## WEST SUSSEX COUNTY COUNCIL CONSULTATION

| <b>LOCATION:</b>       | Manor Nursery High Street Angmering BN16 4AW                                                                                                                                                                                               |
| <b>SUBJECT:</b>        | A/86/20/DOC<br>Approval of details reserved by condition imposed under permission reference A/51/14/OUT: 7 - car parking 9 - roads, footways &c 10 - CMP 29 - pedestrian & cycle linkages & vehicular access<br>More information received. |
| <b>RECOMMENDATION:</b> | No objection                                                                                                                                                                                                                               |

DRAWN M Pacifico		DATE May 2019	PROJECT NO. 22995
ENGINEER S Magowan		CHECKED	REV.
SCALE As Shown @ A1		DRG. NO. 105	REV. A

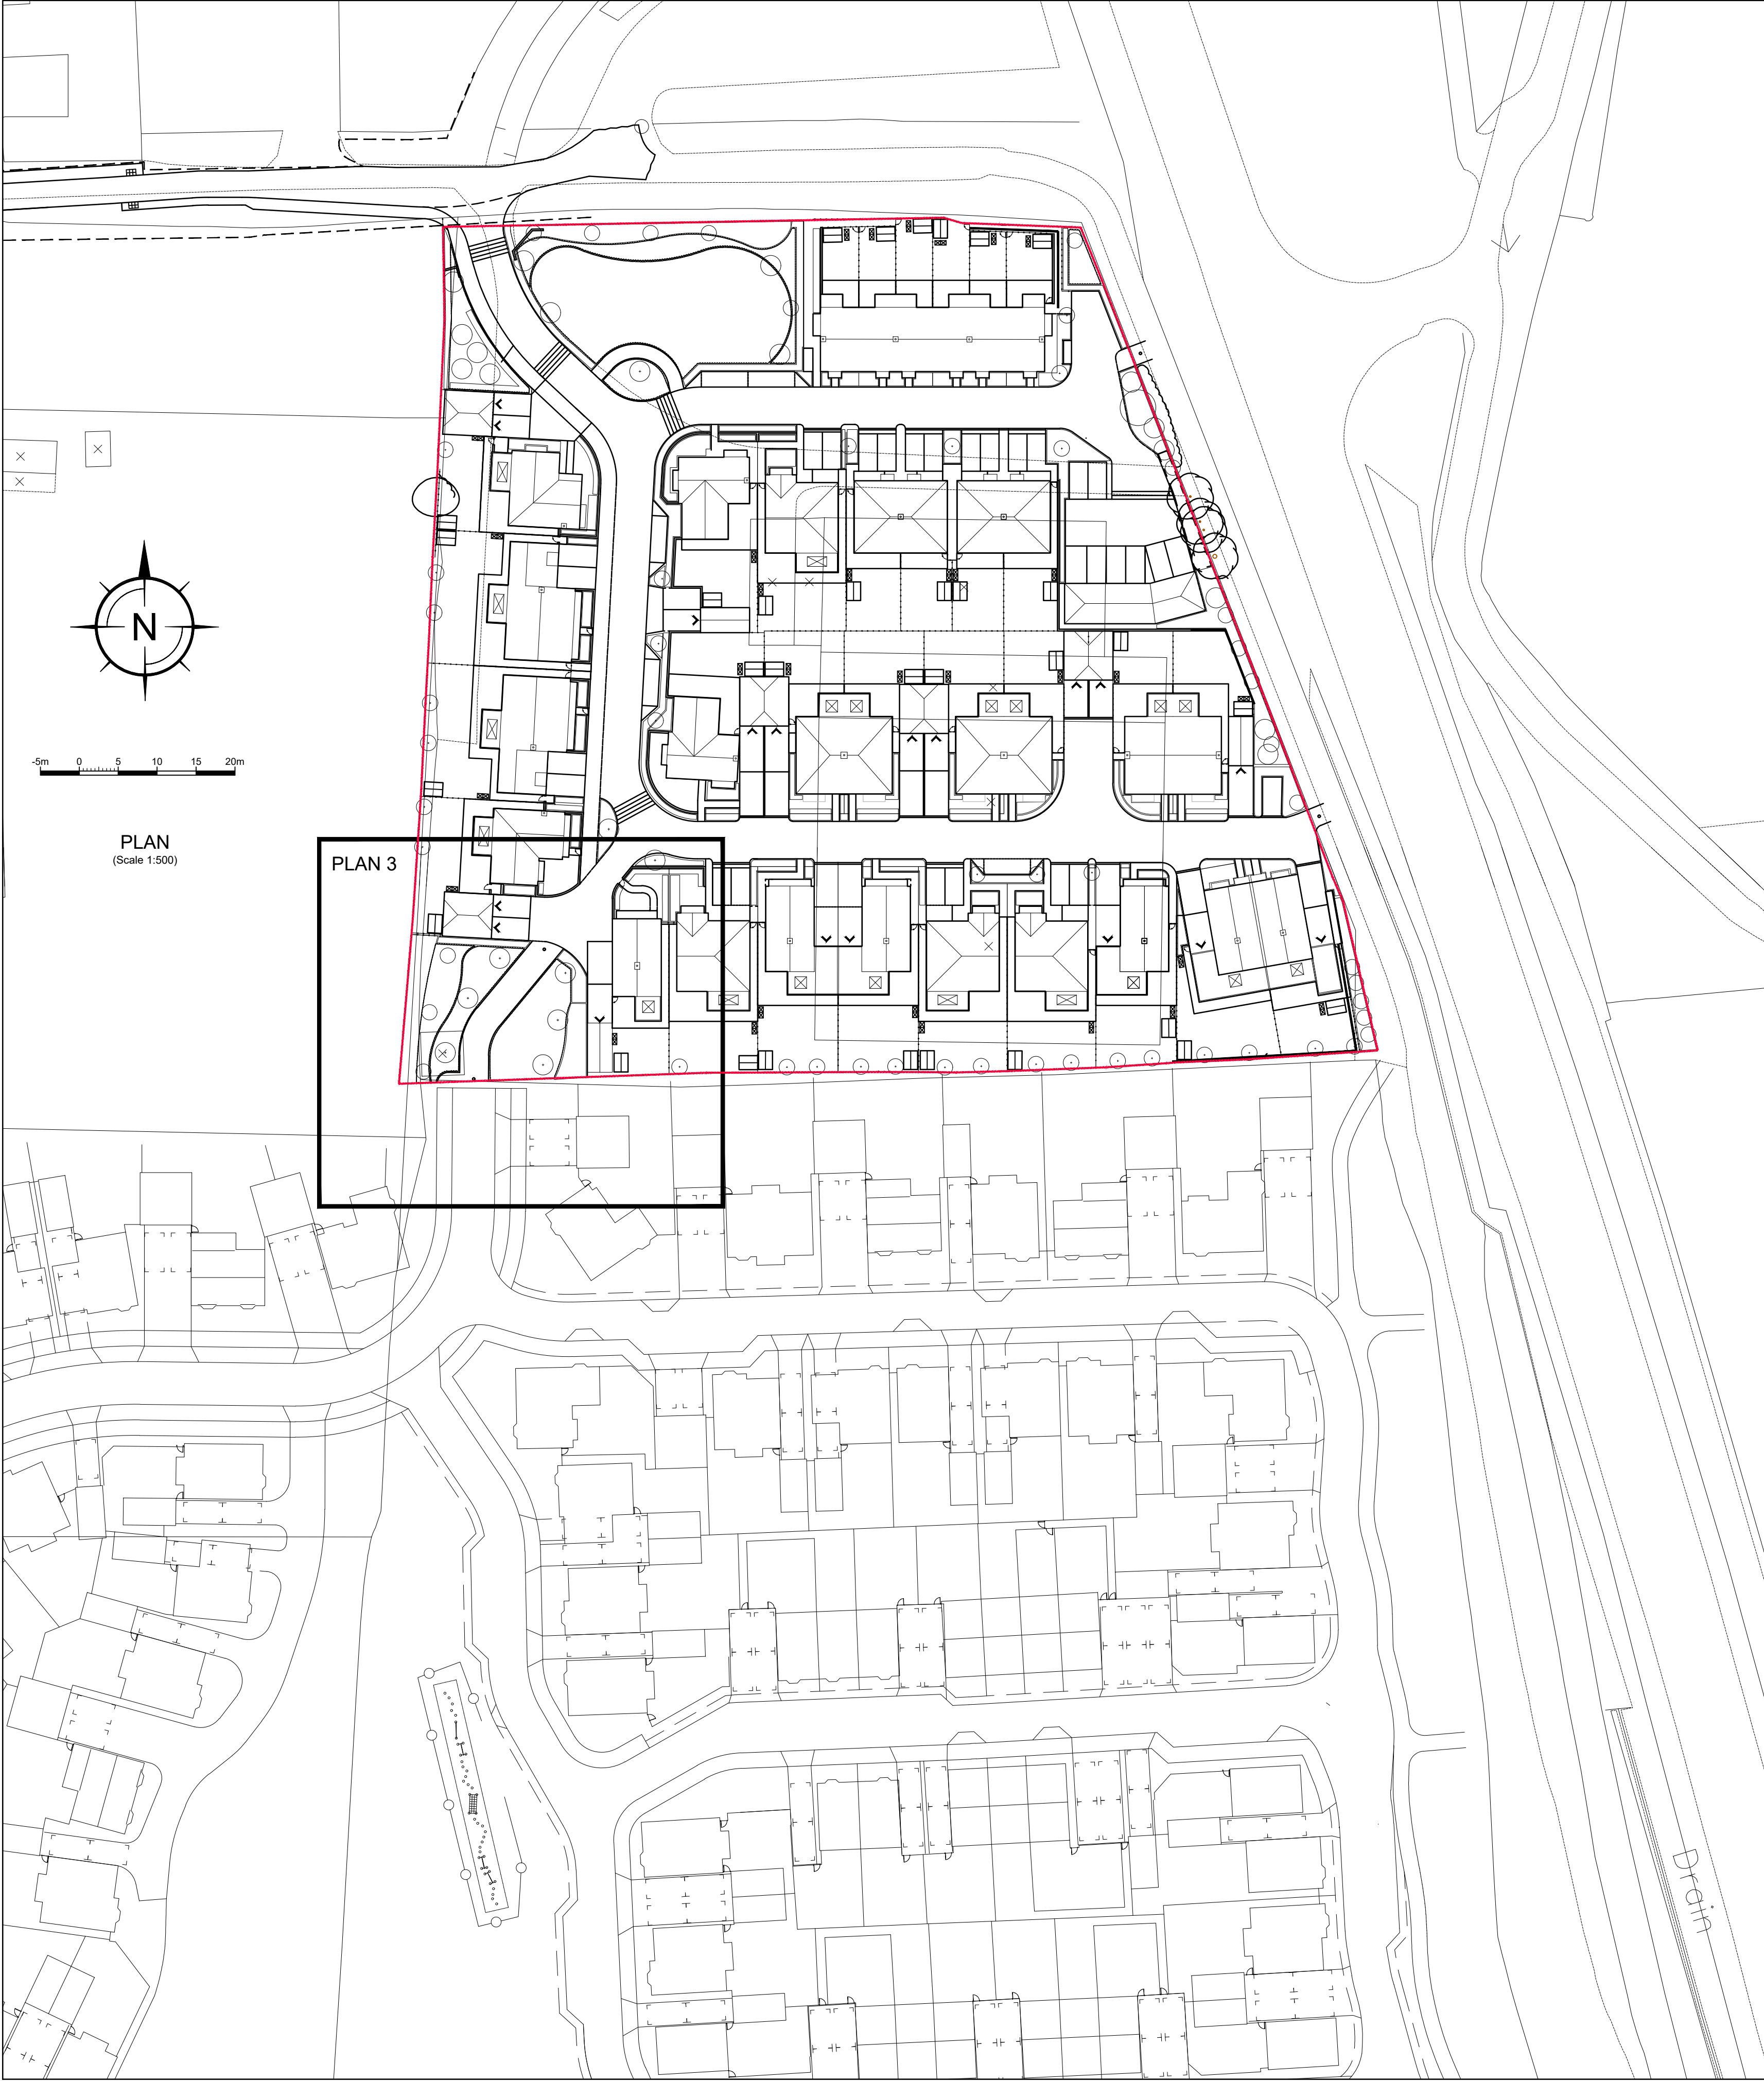
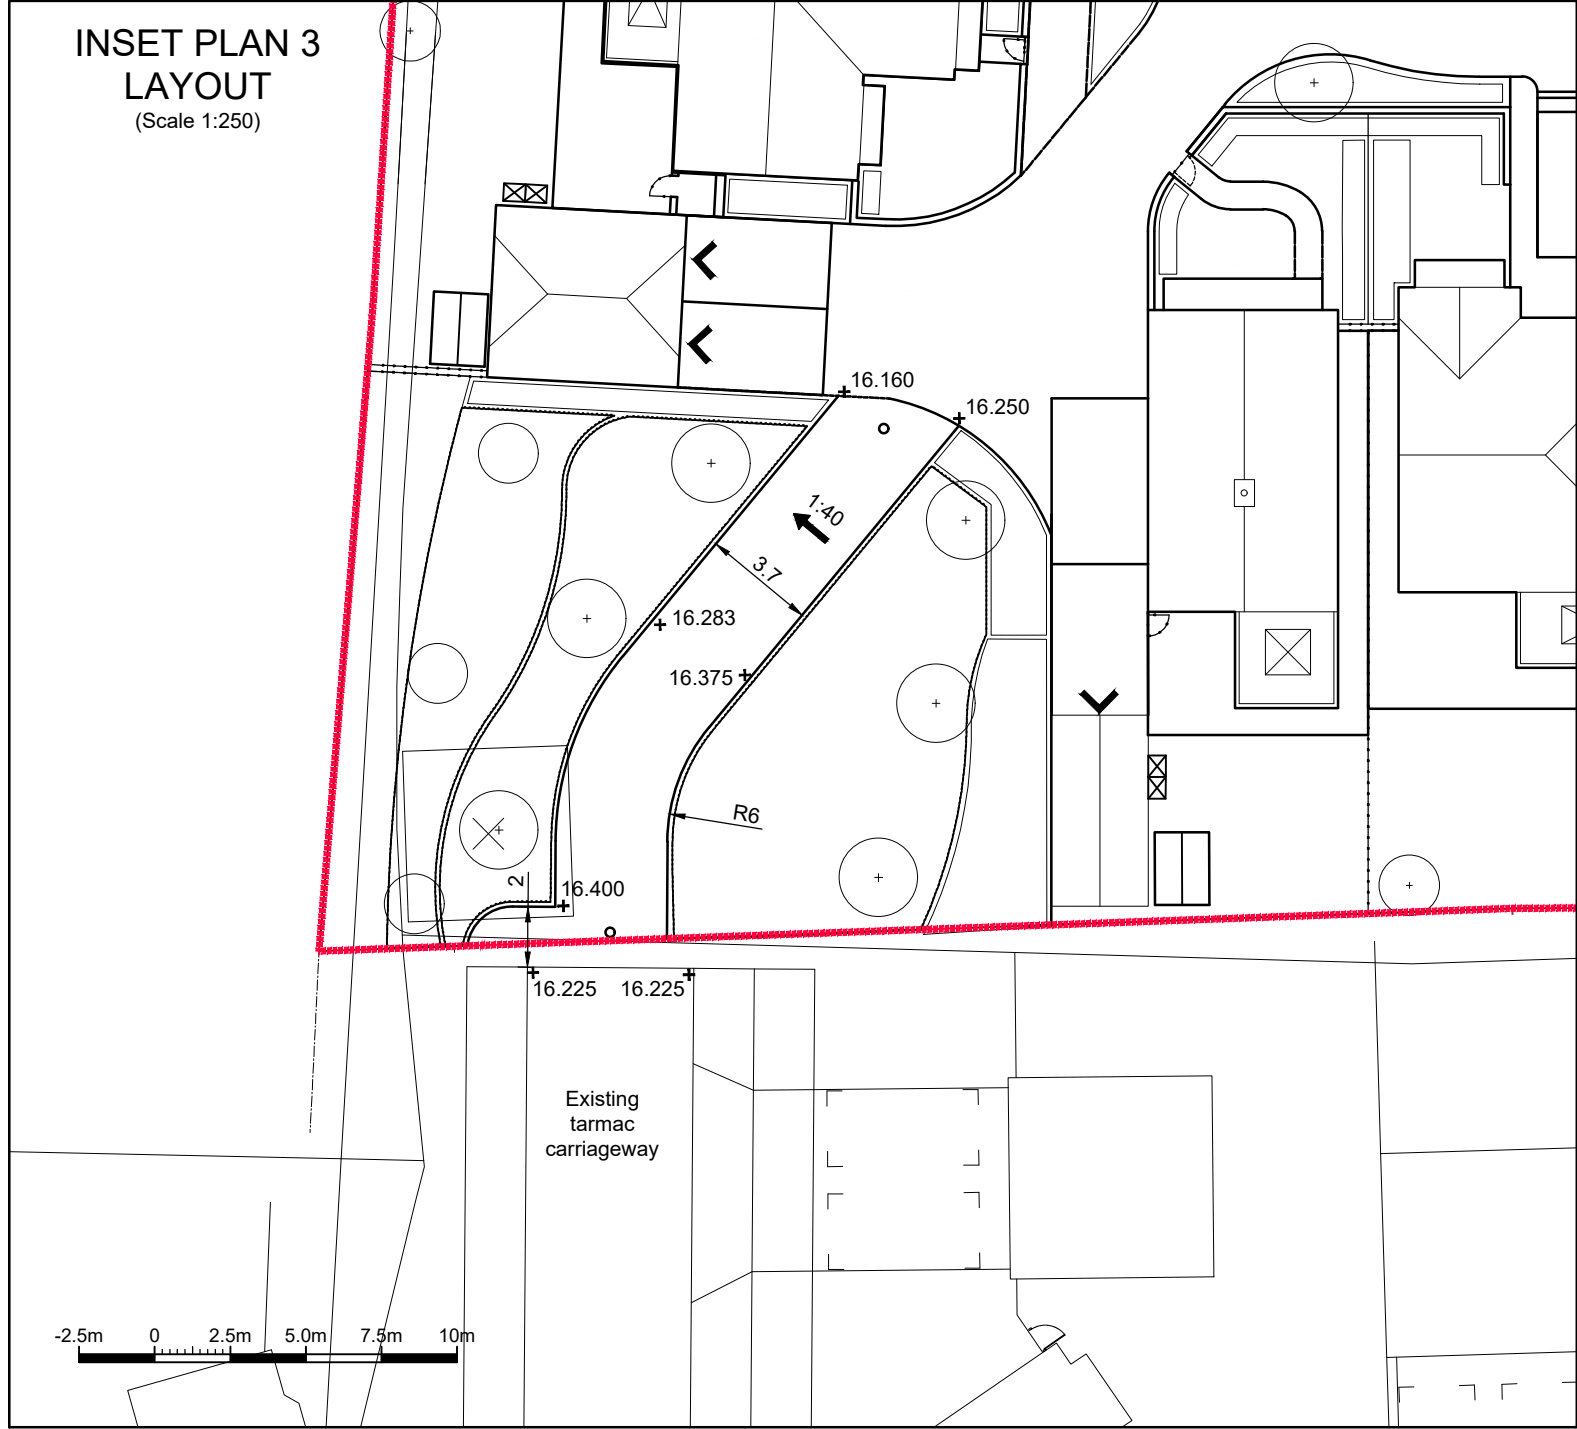
Cyclists would be able to join the highway of the development to the south as the access from Manor Nursery to Land to the east of Roundstone Lane would join up as illustrated in the Site Layout (105 A).

The layout as illustrated in Site Layout (105 A) is the same as the site layout as approved under the Reserved Matters application (Proposed Site Layout reference 100 P9). In this regard, it is considered that Condition 29 has been addressed in full and has already been agreed by WSCC Highways during the determination of the RM application (refer to WSCC Highways attachment dated 3 October 2018).
